BOGNOR REGIS TOWN COUNCIL

31st October 2019

Re: Planning applications BR/120/19/PL and BR/121/19/L: The Bandstand, The Promenade, Bognor Regis

A	MINOR AMENDMENT	16.04.19
REV	DESCRIPTION	DATE
PROJECT	BOGNOR REGIS BANDSTAND	
	THE ESPLANADE	
	BOGNOR REGIS	
	WEST SUSSEX	
DRAWING TITLE	PROPOSED ELEVATIONS, FLOOR PLAN AND ROOF PLAN

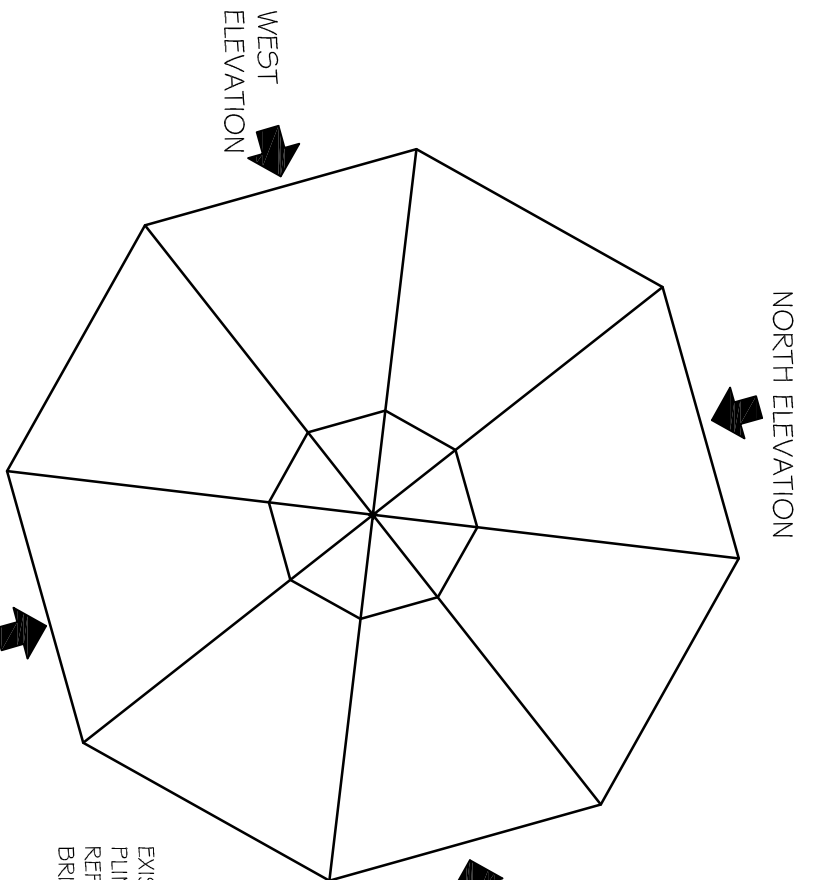
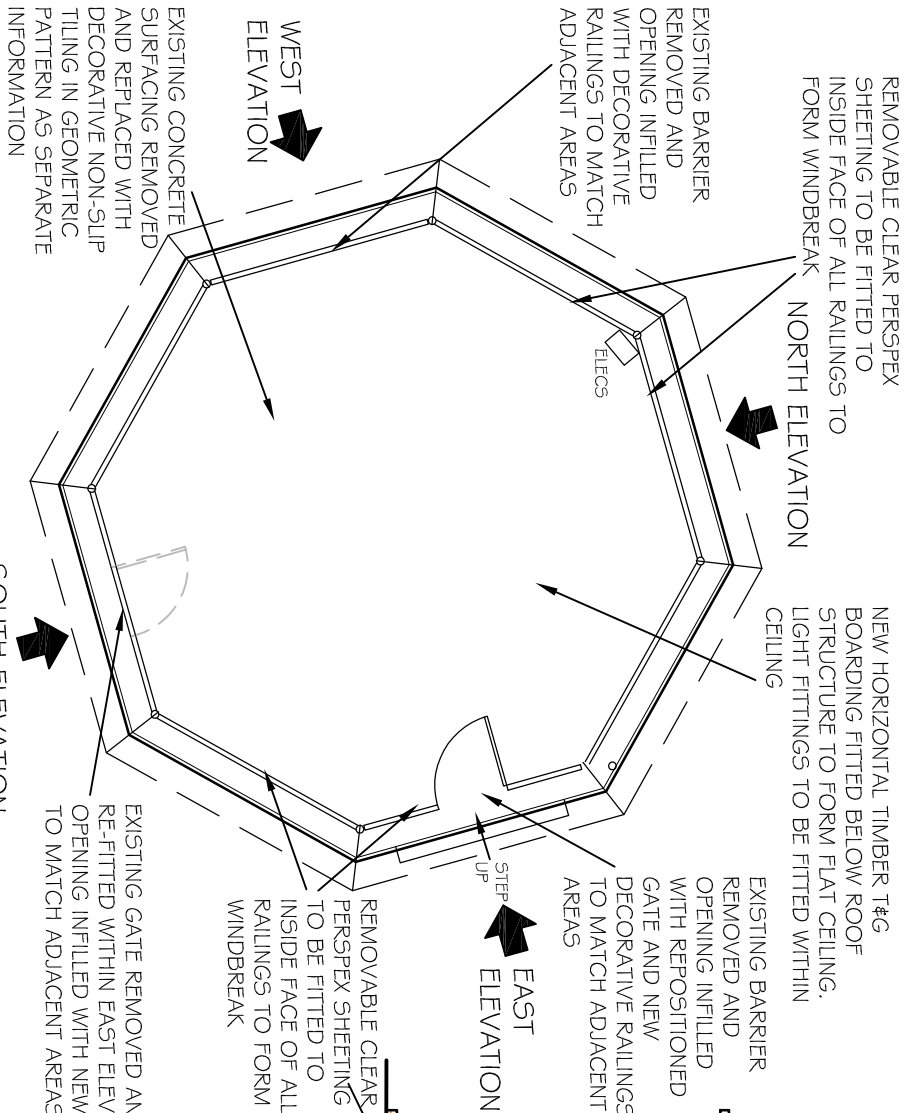
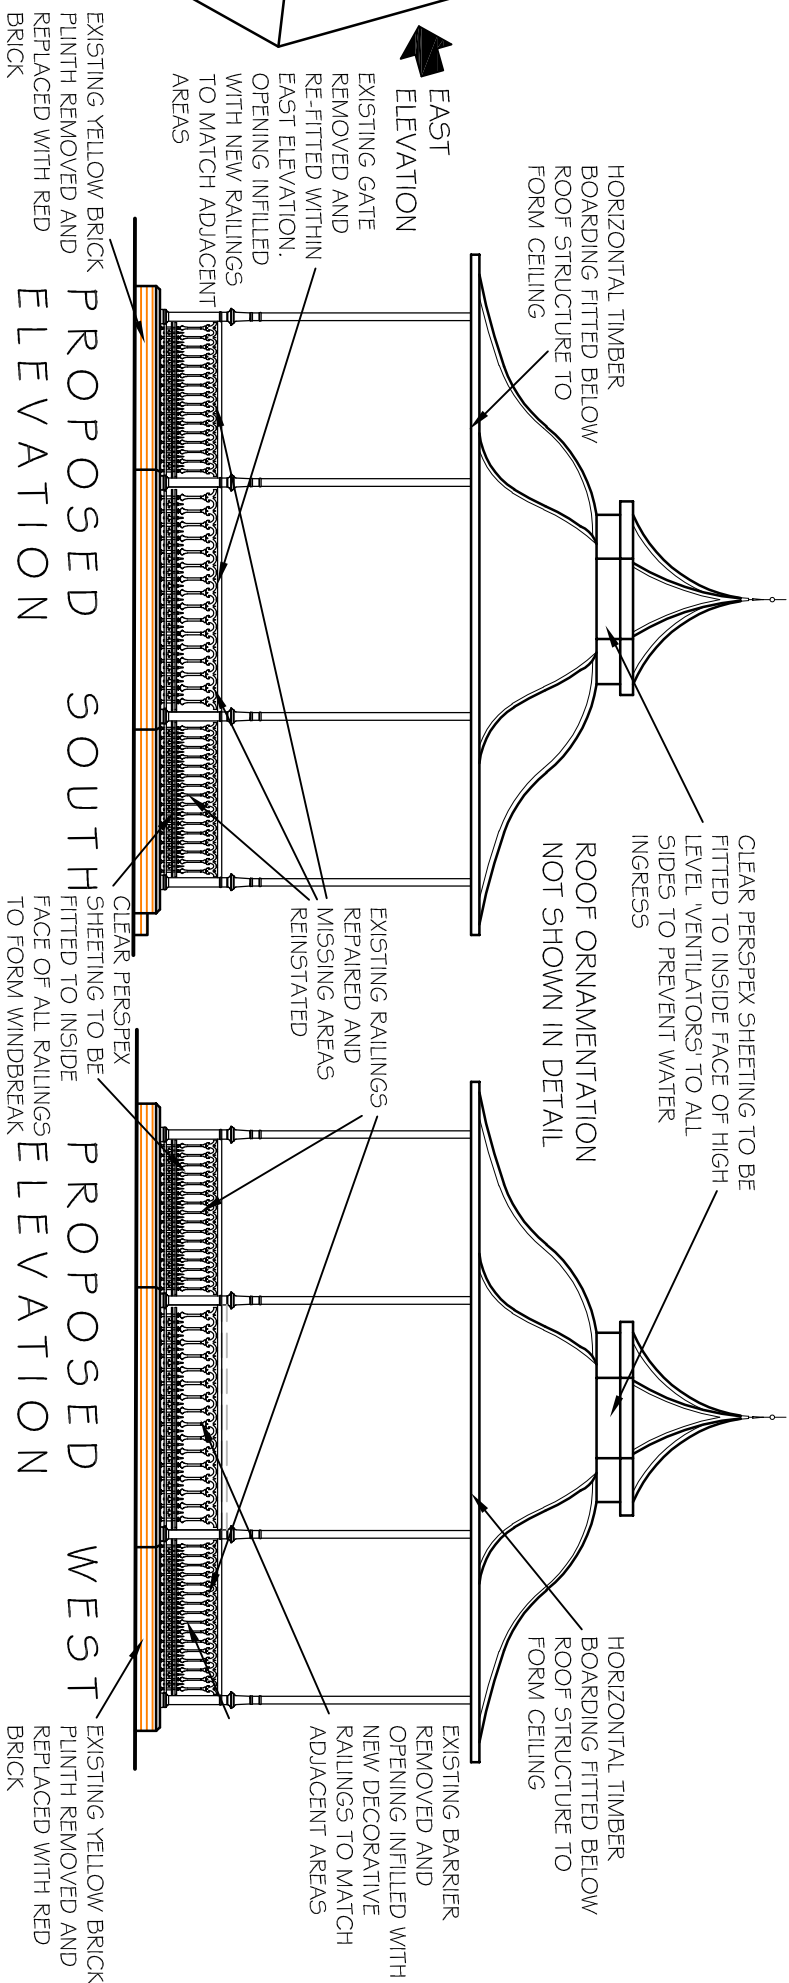
Whilst Members acknowledged the omission, for now, of the previously proposed Perspex sheeting to the railings there remained concern about the safety of Perspex being fitted at high level, particularly during high winds.

Additionally, having considered the amendments submitted by the applicant, Members continue to have concerns that alterations and repairs would be in keeping with the Listed Building. The Committee agreed that the Bandstand on the Promenade was close to the heart and an iconic part of Bognor Regis.
